OBJECTION to WA/75/18/OUT - Land to the rear of 7 The Meadows, Walberton

We live next door, north/north east of the proposed development site and are writing to ask that Arun District Council refuse this planning application from Mr A R Wright & Mrs N Wright.

WA/75/18/OUT

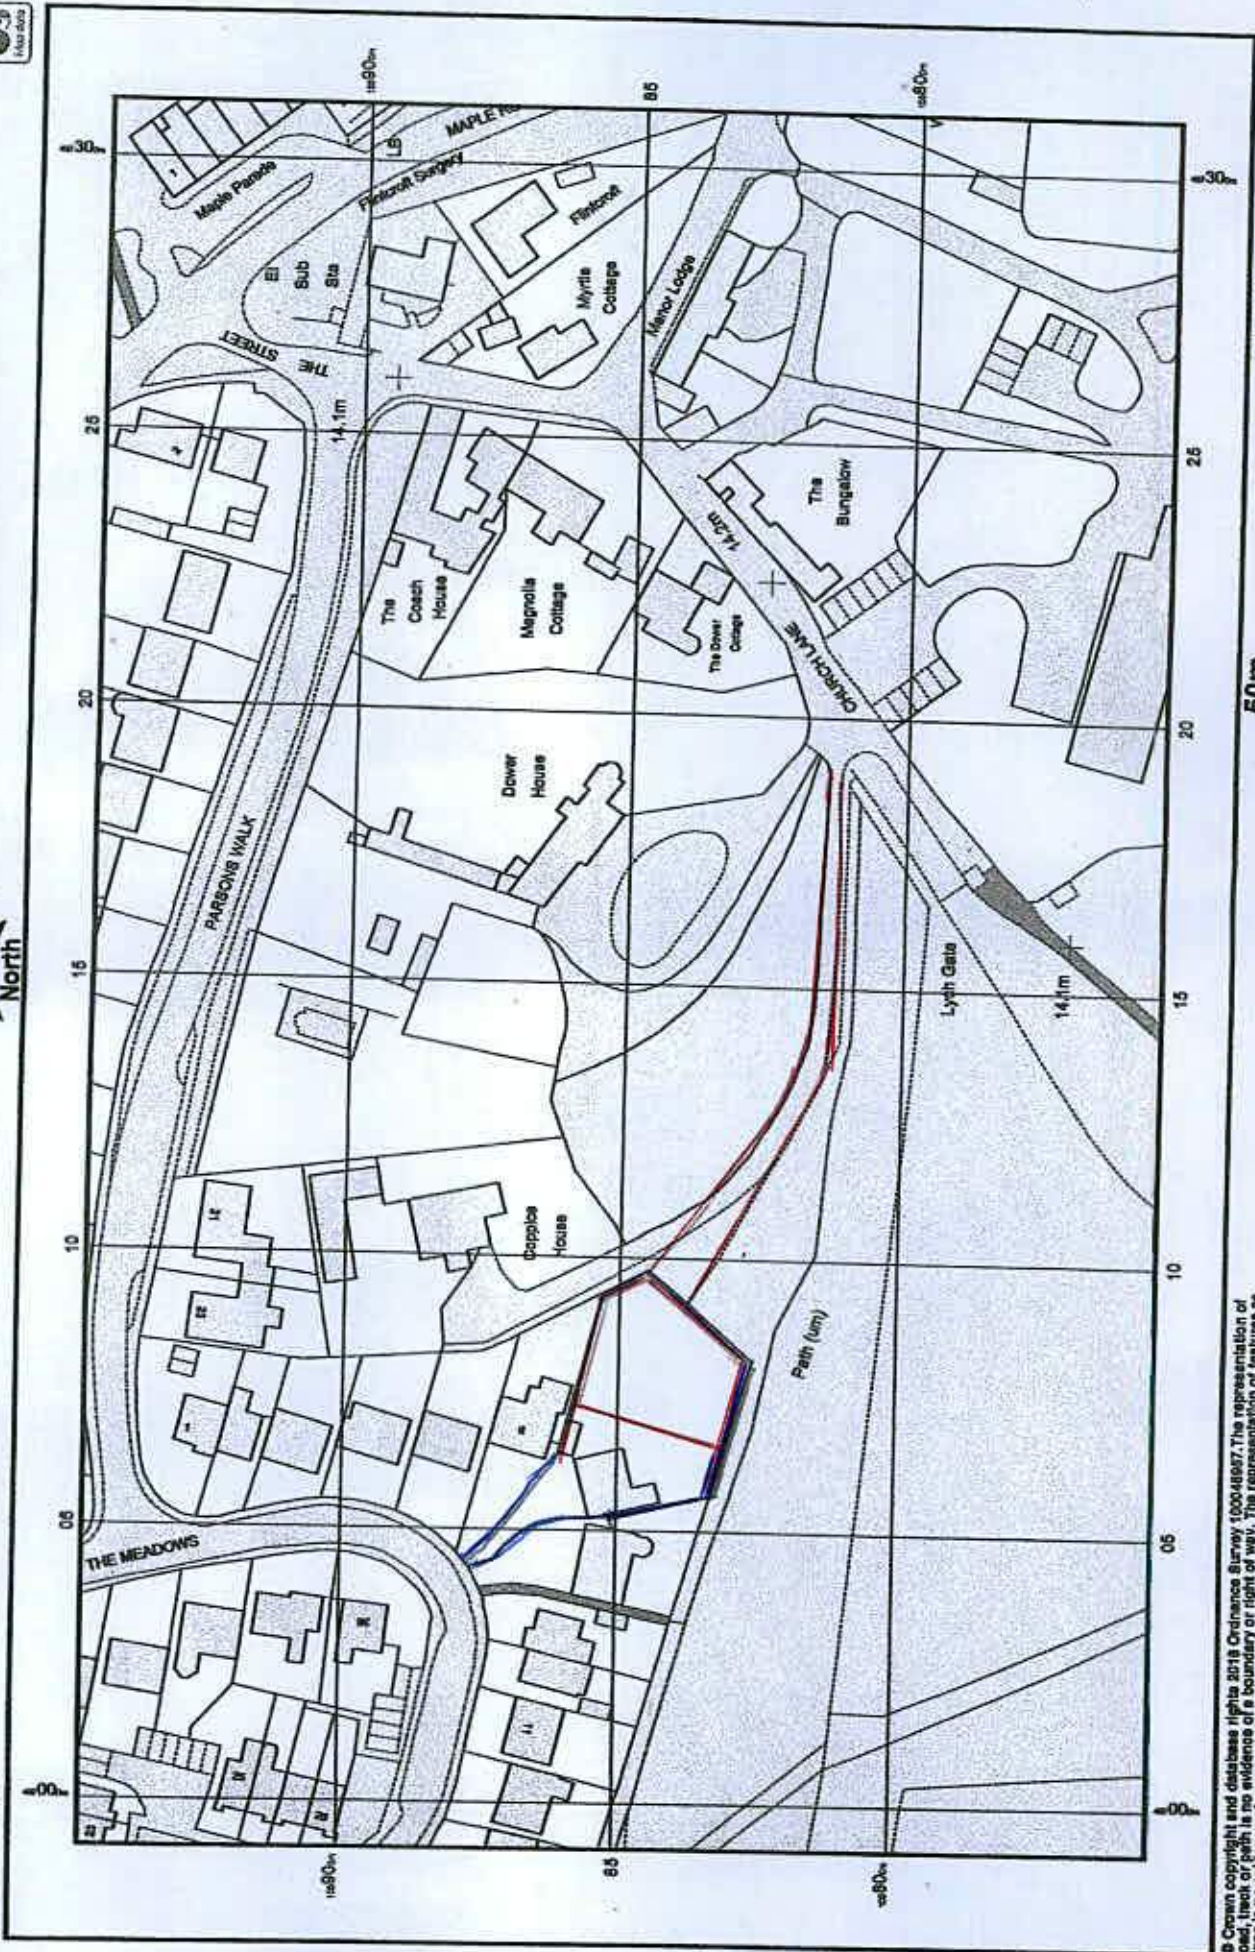
- The proposals involve the creation of a new access road via an existing track used by Coppice House. The formation of the new access will likely involve the removal of existing trees east of the site. Although these trees are not believed to be protected by TPOs they clearly contribute to the setting of the nearby Listed property. Their removal will impact on the setting of a listed building (Dower House, Church Lane, Walberton).

- Similarly, a proportion of the new plot will fall within the canopy of existing trees (see photographs below). This will lead to both poor living conditions for future occupants of the new dwelling and in turn put pressure on the council to agree the felling of existing trees in the future.

- It is likely that any new dwelling will be positioned on an east west axis on the new site and this will be within close proximity of the rear elevations of both No.6 and No.7 The Meadows. This will undoubtedly lead to overlooking and overbearing impacts.

- Finally, whilst it is understood the application is for outline permission (with all other matters reserved), the principle of the development must still be assessed by the LPA when determining the application. The application provides no indication of size of the proposed dwelling or even a basic site layout. The scheme is not supported by a tree report or an ecology assessment and without these it is difficult for the LPA to truly form a reasonable opinion on the scheme. Indeed, without knowing the potential site constraints (such as root protection areas or presence of protected species) the principle of the development cannot confidently be assessed by the LPA or be considered acceptable.
